Address: Flat 2, 61 Belgrave Gardens, London, NW8 0RE,

Proposal: Details of facing materials pursuant to Condition 4 of planning permission dated 12 April 2023 (RN: 23/01011/FULL).

Proposed Materials

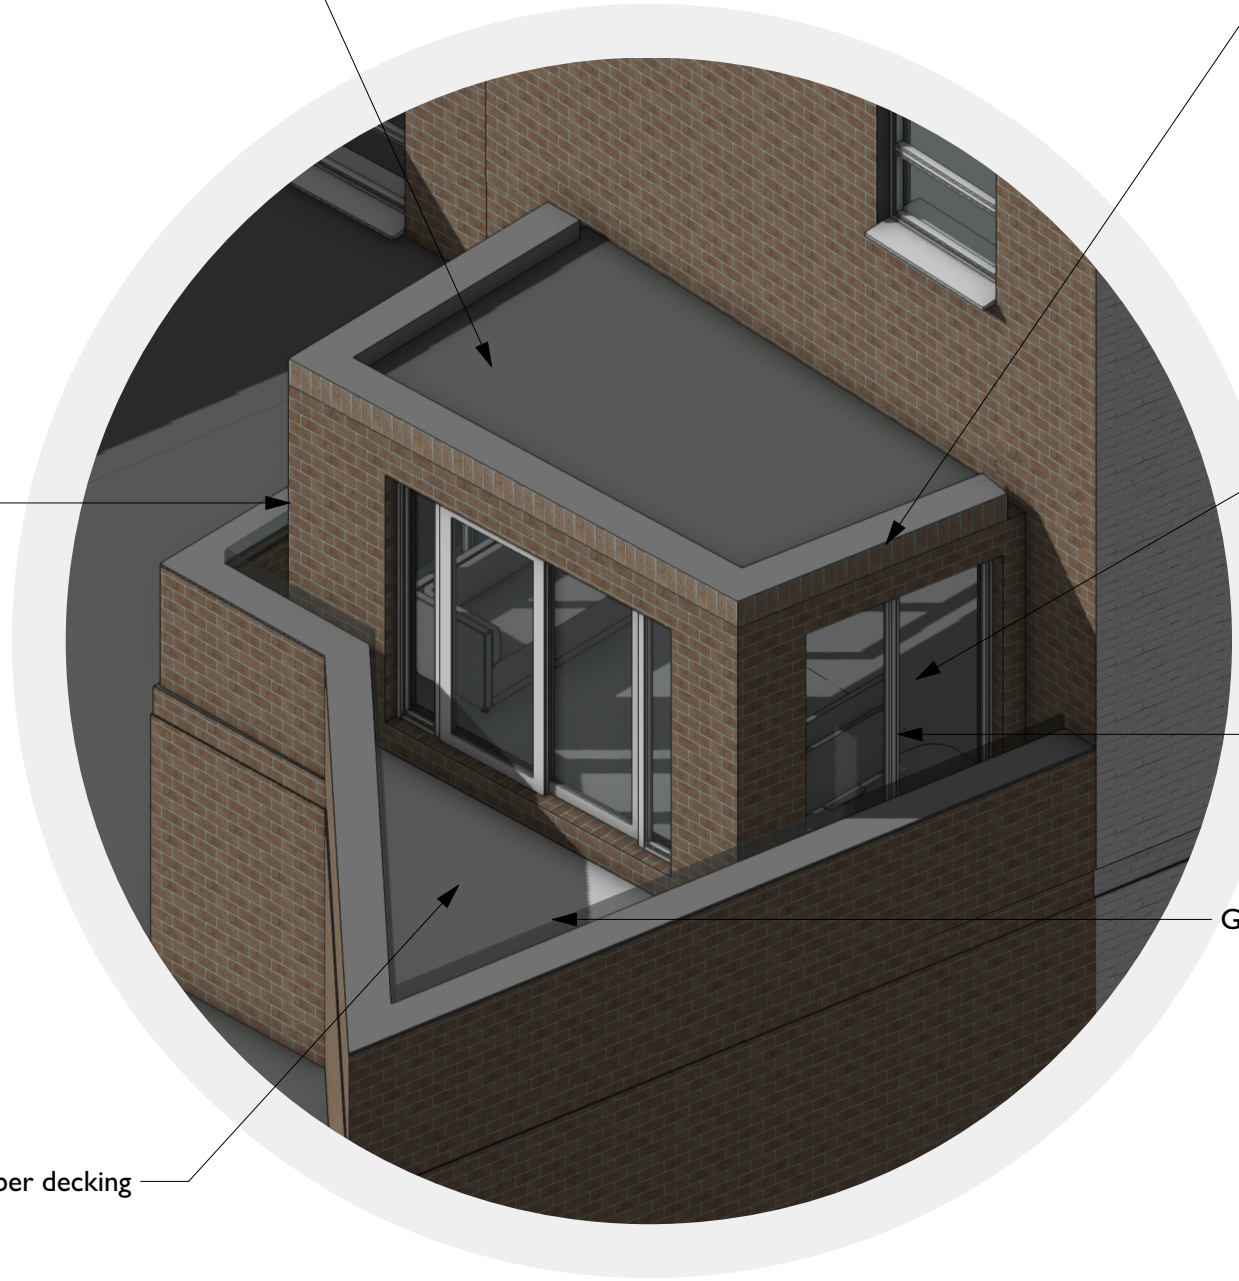
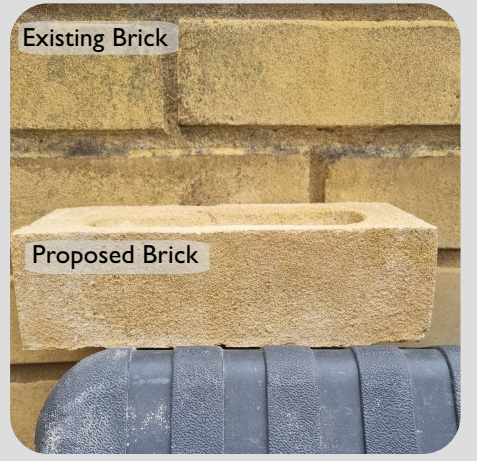
- 1 In order to validate the application a representative sample panel or very high quality photographs are required in order to make a sufficient comparison between the existing and proposed brickwork.

Please submit a high quality close up photo - a photo of a single brick with no bond etc is not sufficient enough for assessment.
